Application No: BR/39/26/PL
Site Address: Bognor Regis Sports Ground Hawthorn Road Bognor Regis PO21 2UW
Description of works: Replacement of existing 1.8m high fence panels along the perimeter of the sports ground (north and east) with a new 3m high green metal twin bar fence. This application is in CIL Zone 4 (Zero Rated) as other development.

Thank you for your internet representation made on 18th May 2026 which has been recorded as an objection with the comments as follows:

PROPOSED NYEWOOD LANE FENCE ELEVATION (125 Lm)
SCALE 1:200

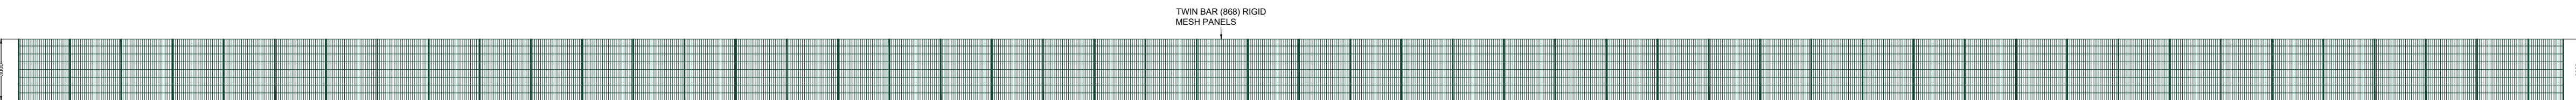
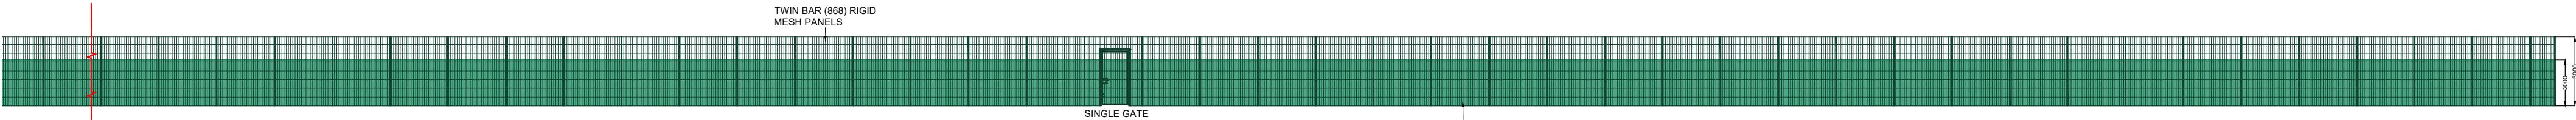
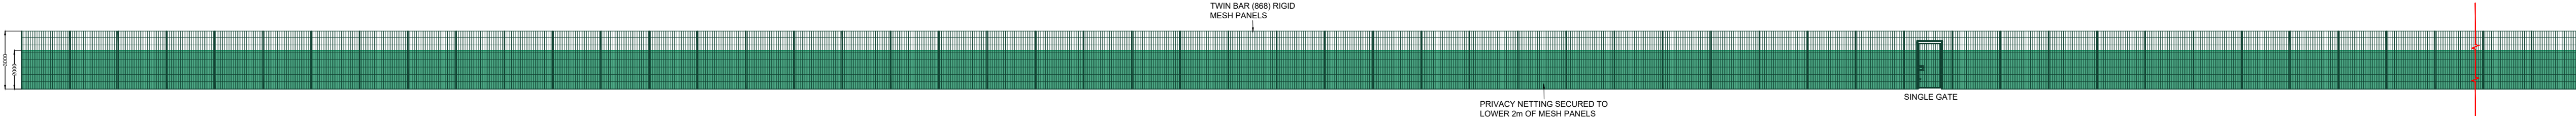
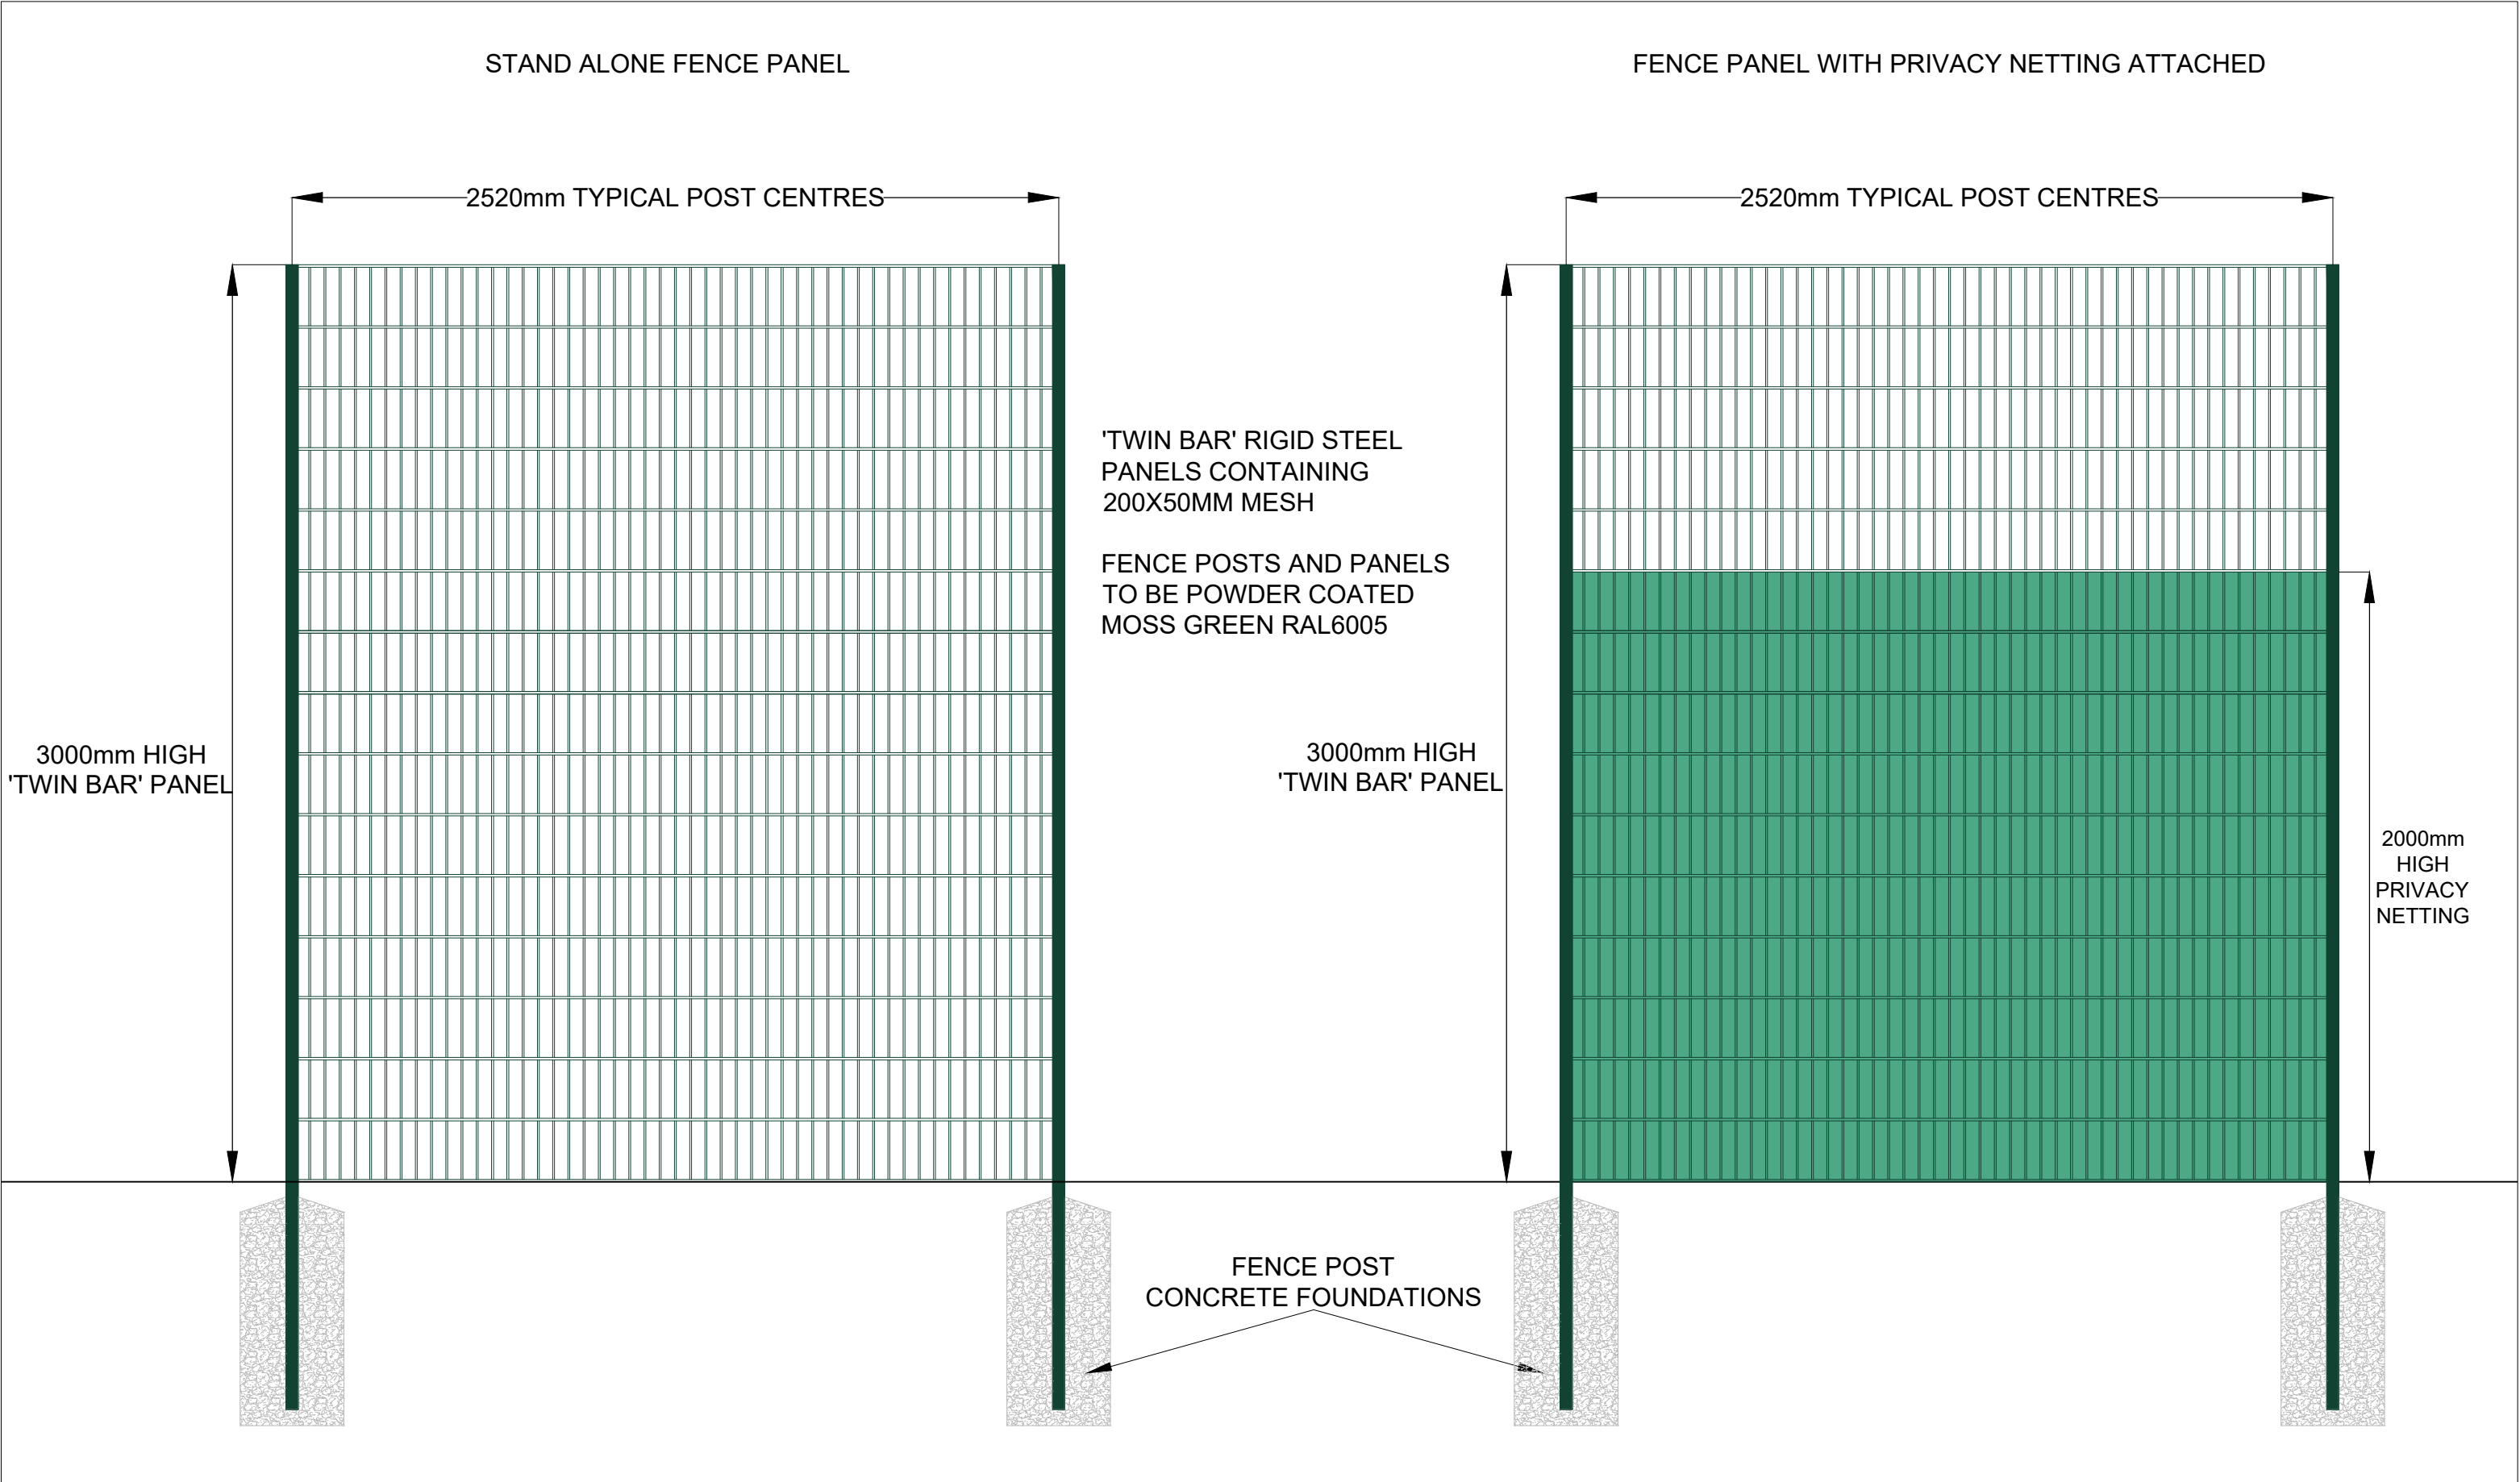
Obtrusive and see no reason as why it should be that height as we have lived here for 30years without any problems.should be the height of the gates at the end of Nyewood lane .
